SANDSTONE PRECINCT

DESIGN REVIEW PANEL - ADVICE 1

7 June 2016

DESIGN REVIEW PANEL - ADVICE 2

EDUCATION BUILDING - WEST

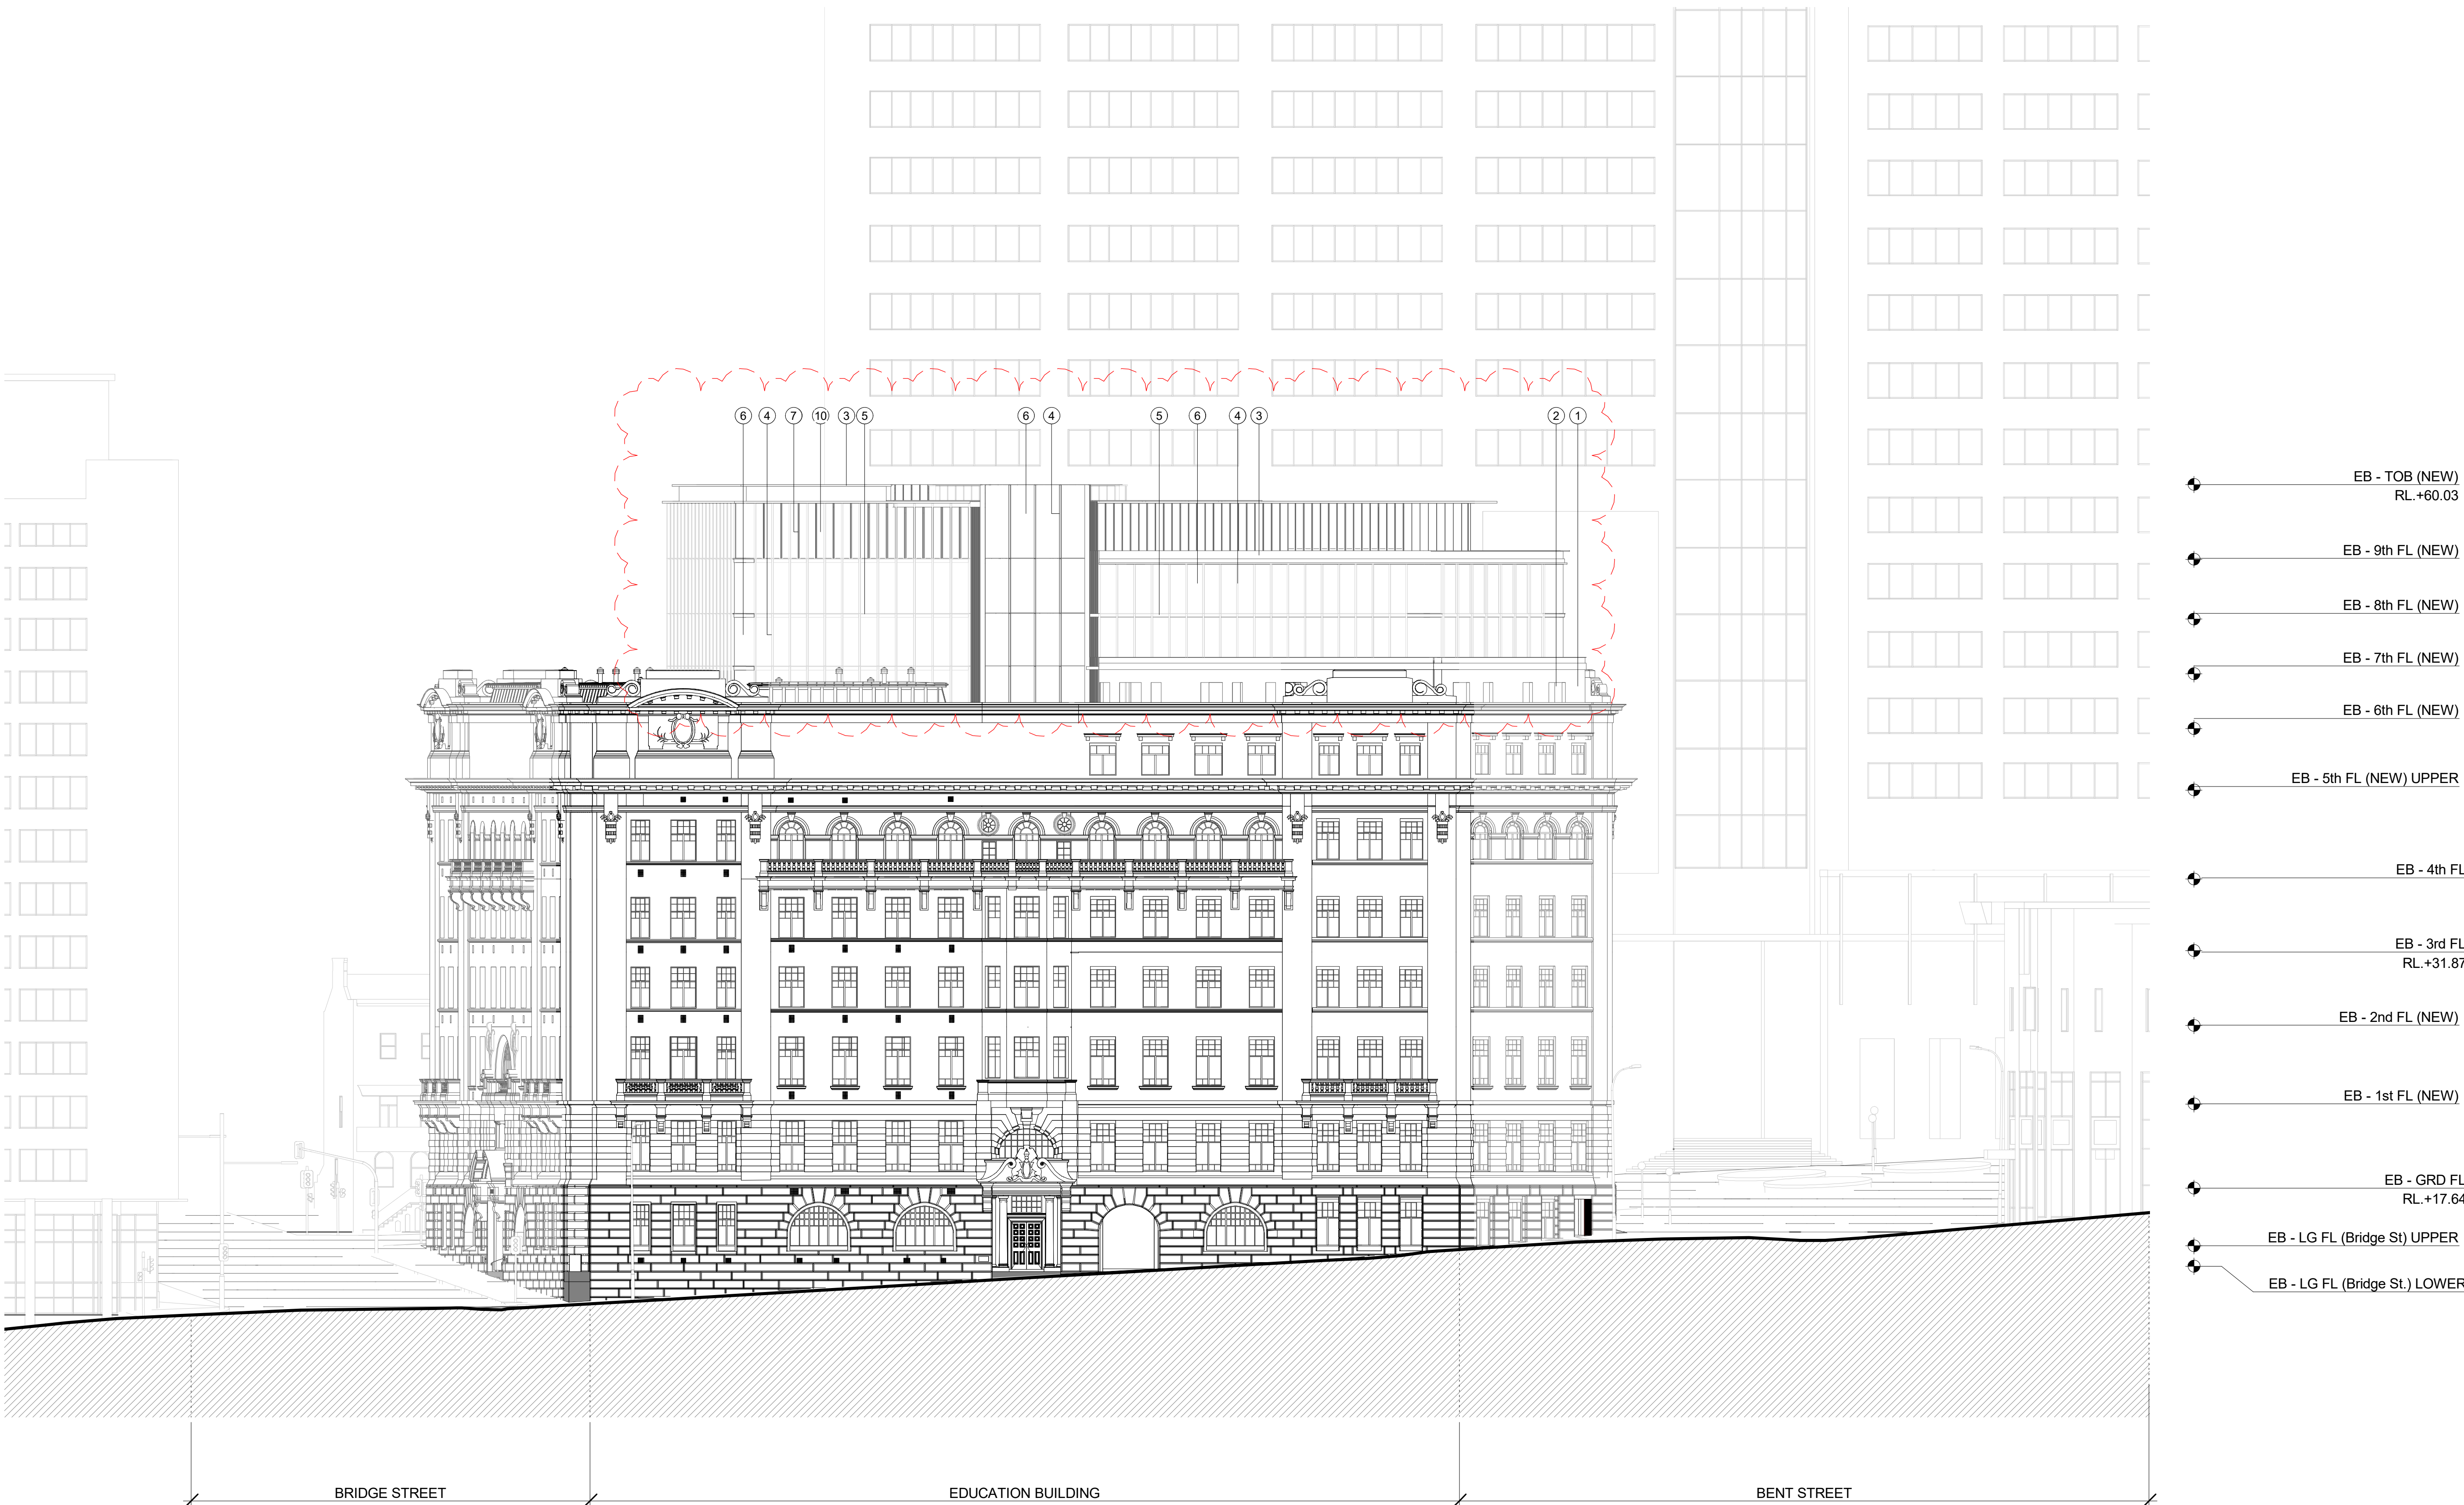
- . The retention Farrer Place lift core wall was reviewed. The DRP believes further investigation of this element is required, noting that the wall's significance was diminished by the removal of the lifts, and questioned its treatment on the reverse side with the lift shaft removed.
- . Courtyard roof design. DRP suggested that holding the glass clear of, and above, the beams would allow for clearer expression of the structure and easier drainage. The beams are to be pre-cast concrete to match the courtyard expression.
- . DRP was concerned with the dominance on the roof of the western tower. IT recommends further consideration of its mass and height as it has greater visibility than the eastern tower and can be seen from Macquarie Place. DRP also queried whether there are options to address the materiality of the western tower to reduce its dominance.
